330 CHURCH STREET, PARRAMATTA

ACCESS REVIEW

Morris-Goding Accessibility Consulting

4th May 2011

A096

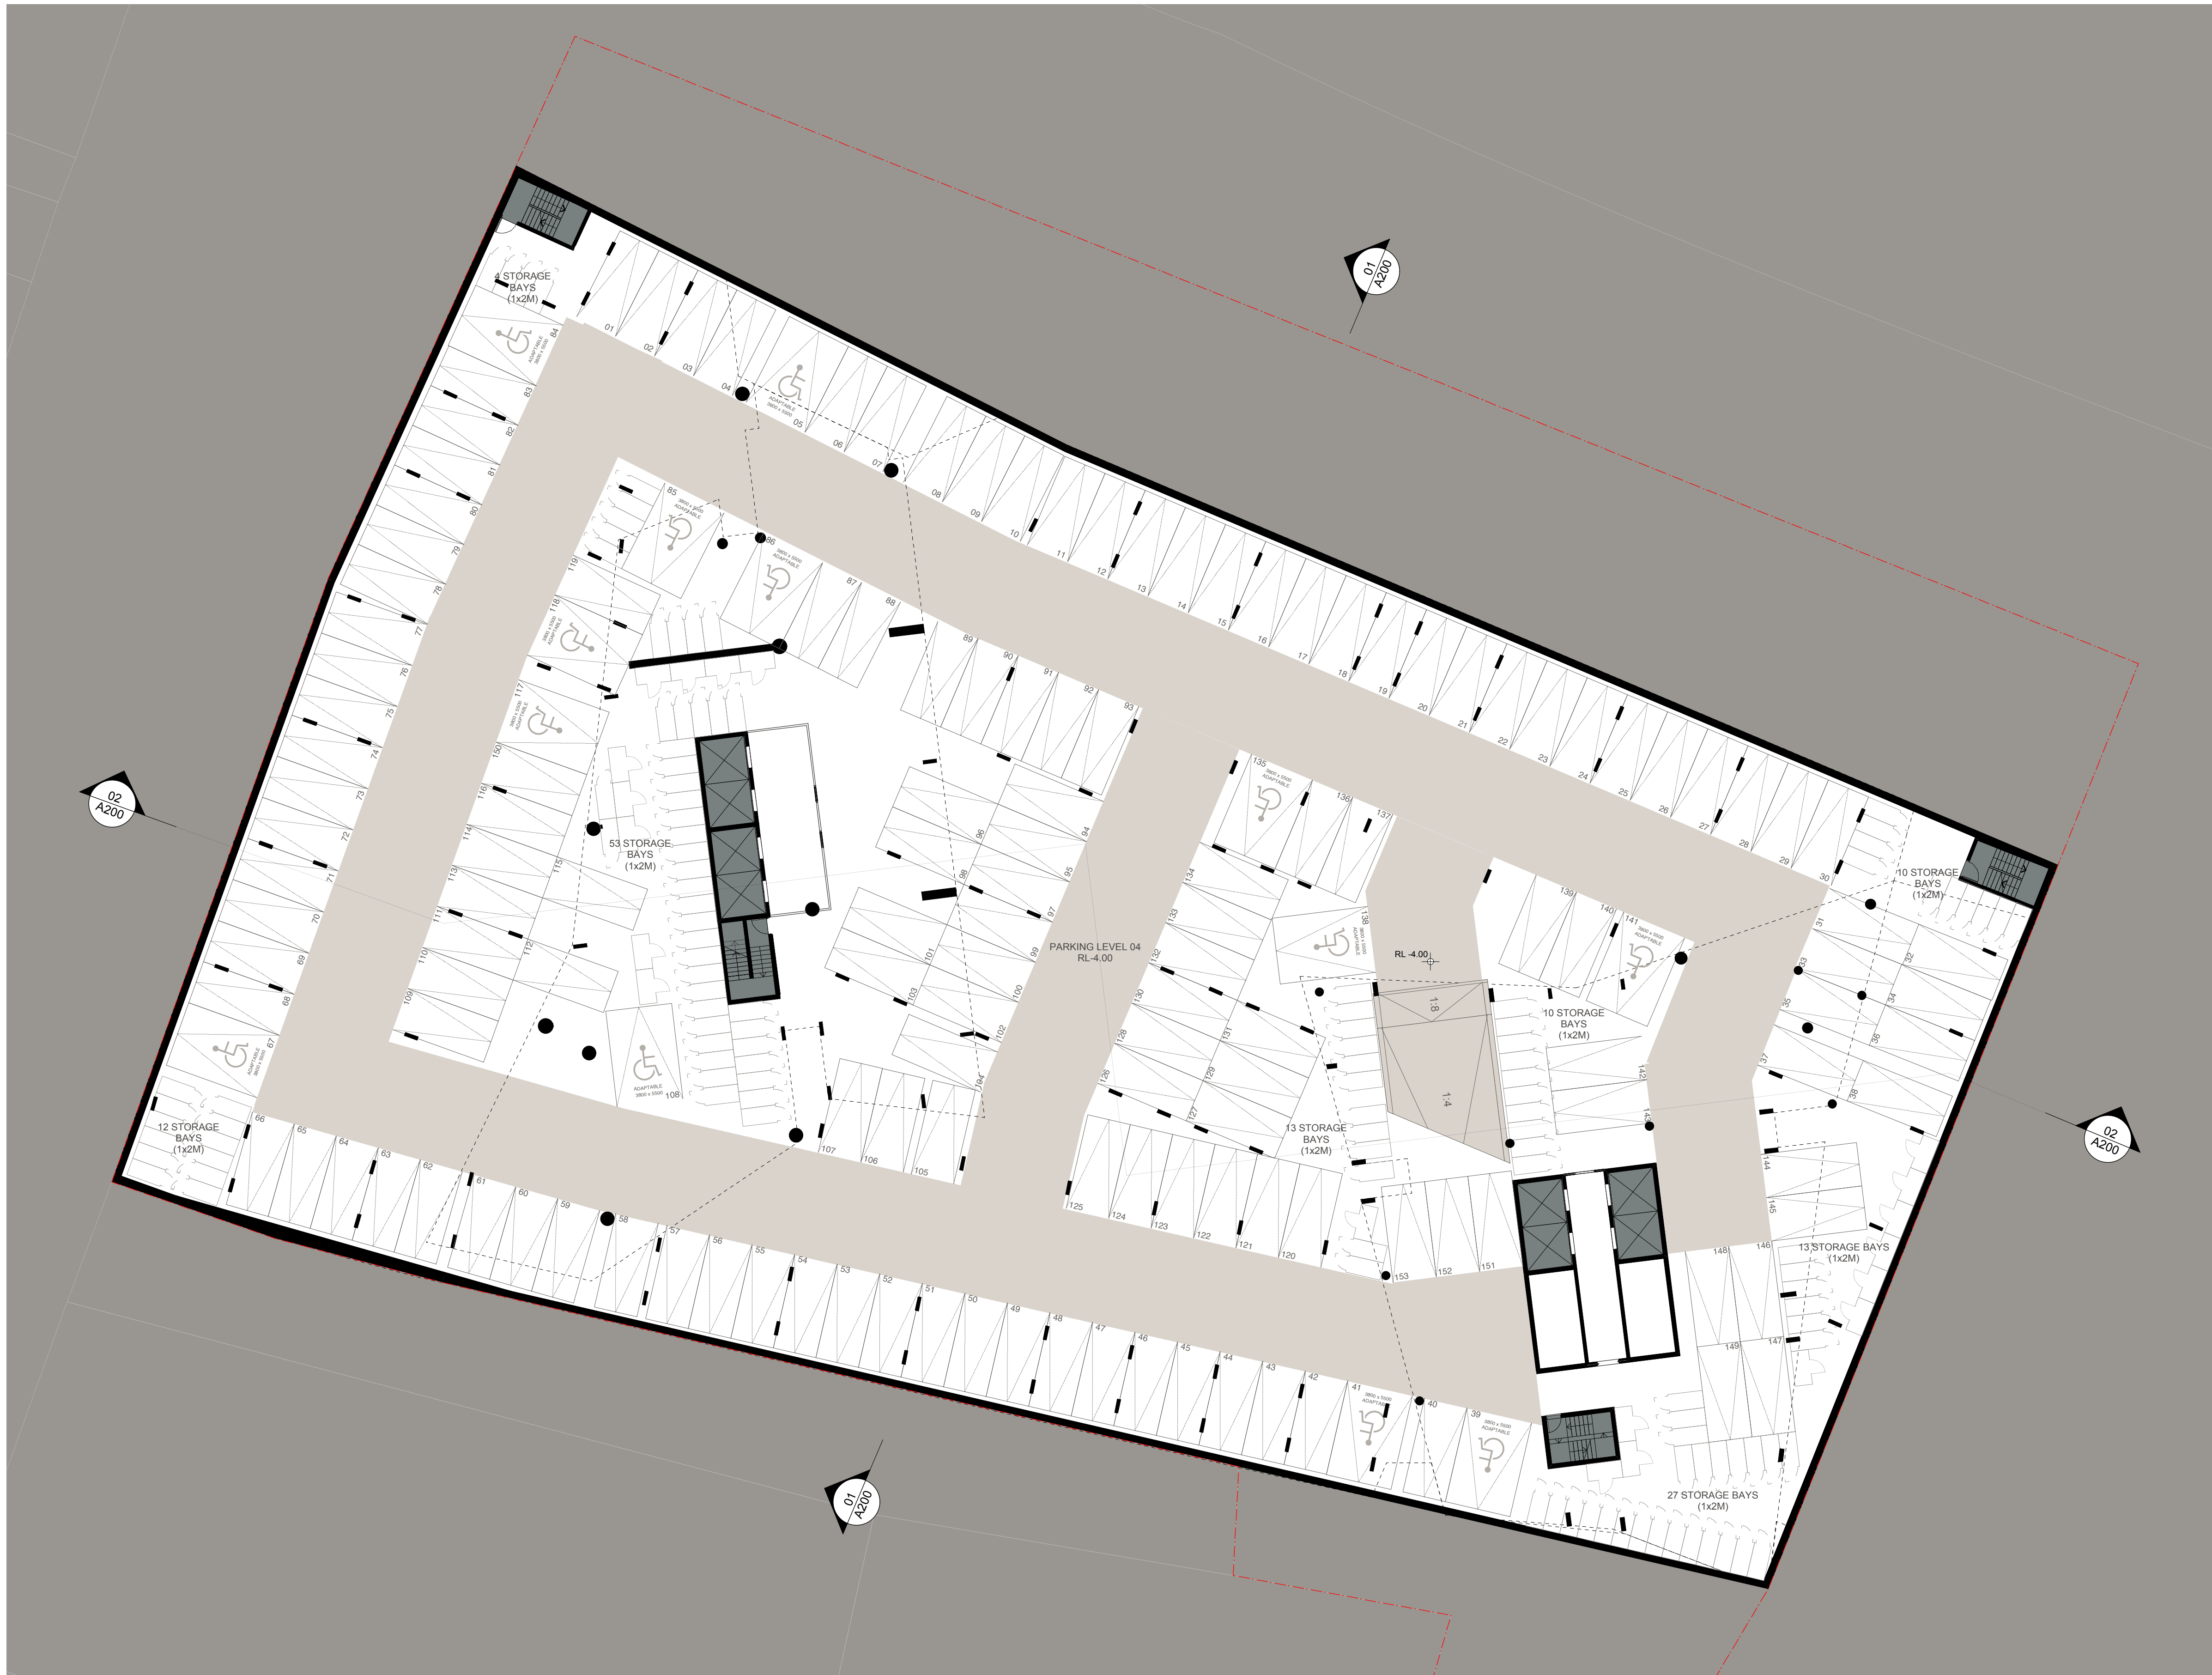
There are 3 basement car parking levels for residential units. A total of 39 accessible car bays have been provided within the development identified for use by adaptable units.

The adaptable unit car bays have 3.8m internal widths compliant with AS4299.

- (i) Locate adaptable unit car bays adjacent to the passenger lift which provides an accessible path of travel to the corresponding adaptable unit compliant with AS4299.
- (ii) Provide 1 visitors' car bay to be designed in accordance with AS2890.6:2009 compliant with the Parramatta City Centre DCP, clause 4.3(e).

- (iii) Each accessible car bay requires a height clearance of 2.5 metres with the approach to each accessible car bay should not have vertical clearance of less than 2.2m.

01 PLAN - PARKING LEVEL 01
1:200 @ A1

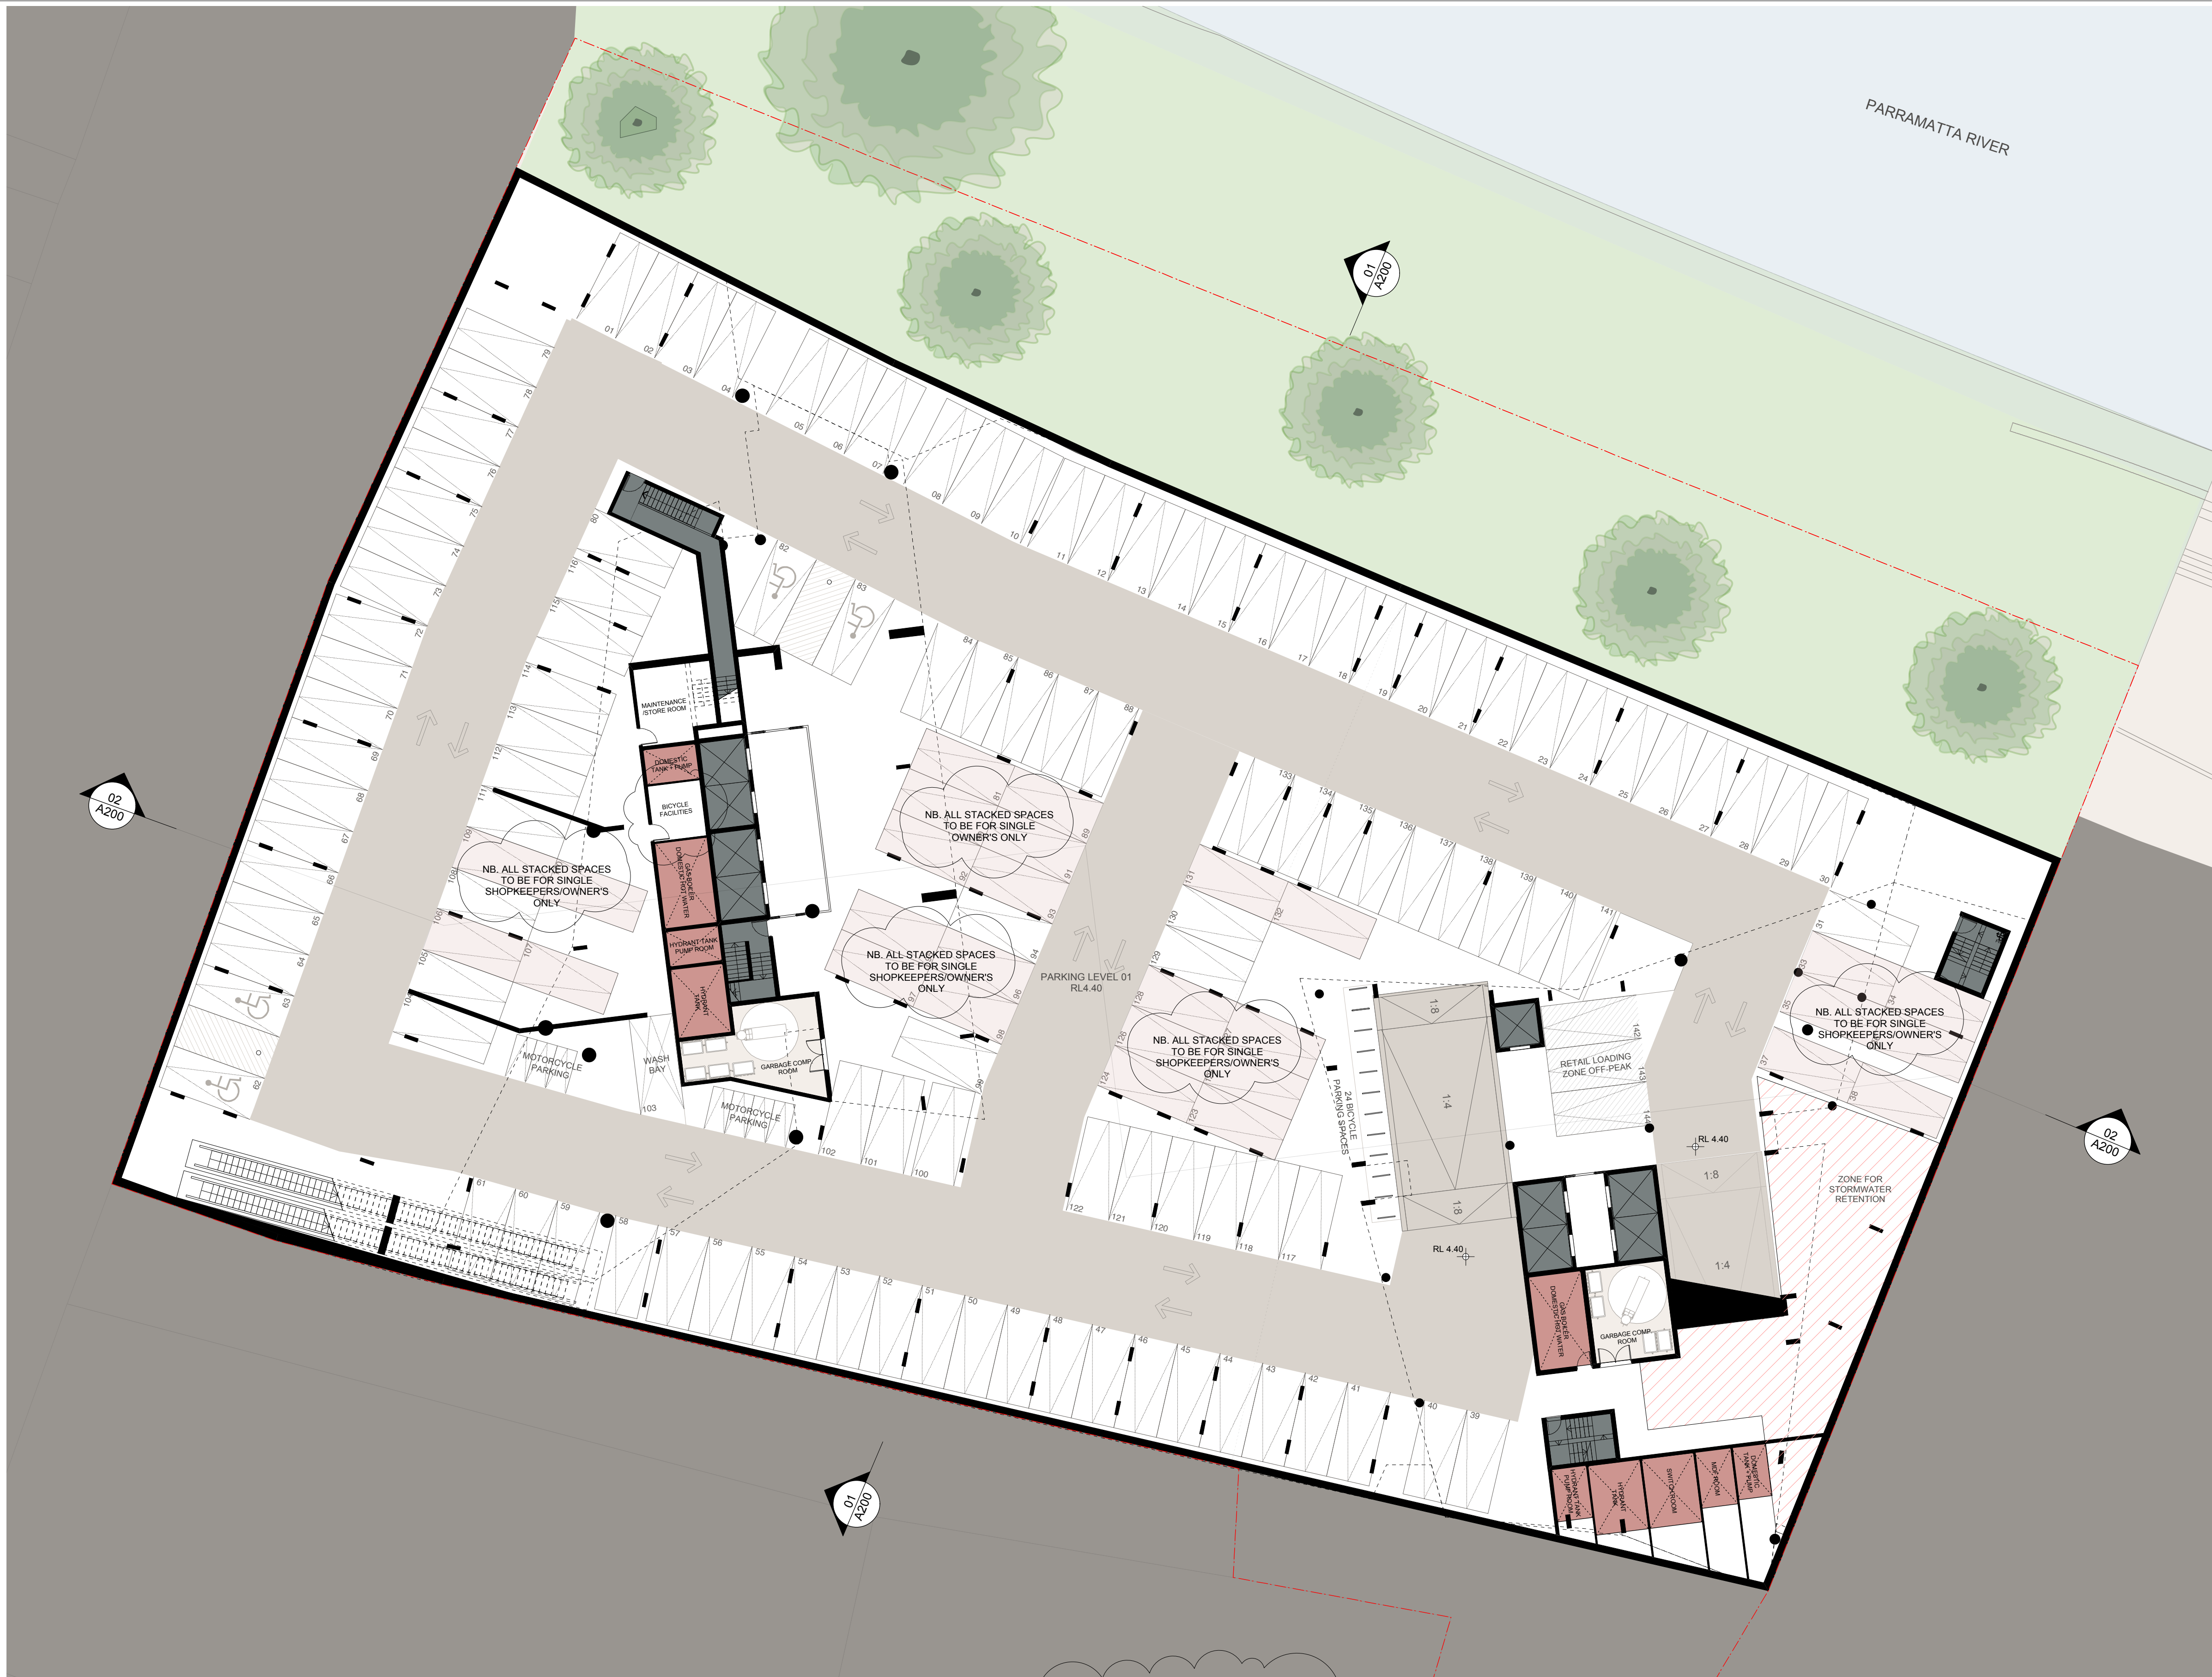
There are 4 car bays provided on level 01 parking with 3 designated accessible retail parking bays and 1 designated accessible childcare parking bay compliant with the DDA Premises Standards and the Parramatta City Centre DCP, clause 4.3(e).

Accessible car bays have internal dimensions of 2.4m x 5.4m with a shared zone adjacent the car bay with internal dimensions of 2.4m x 5.4m with a bollard at the start of the shared zone compliant with the DDA Premises Standards and the Parramatta City Centre DCP.

- (i) Each accessible car bay requires a height clearance of 2.5 metres with the approach to each accessible car bay should not have vertical clearance of less than 2.2m.
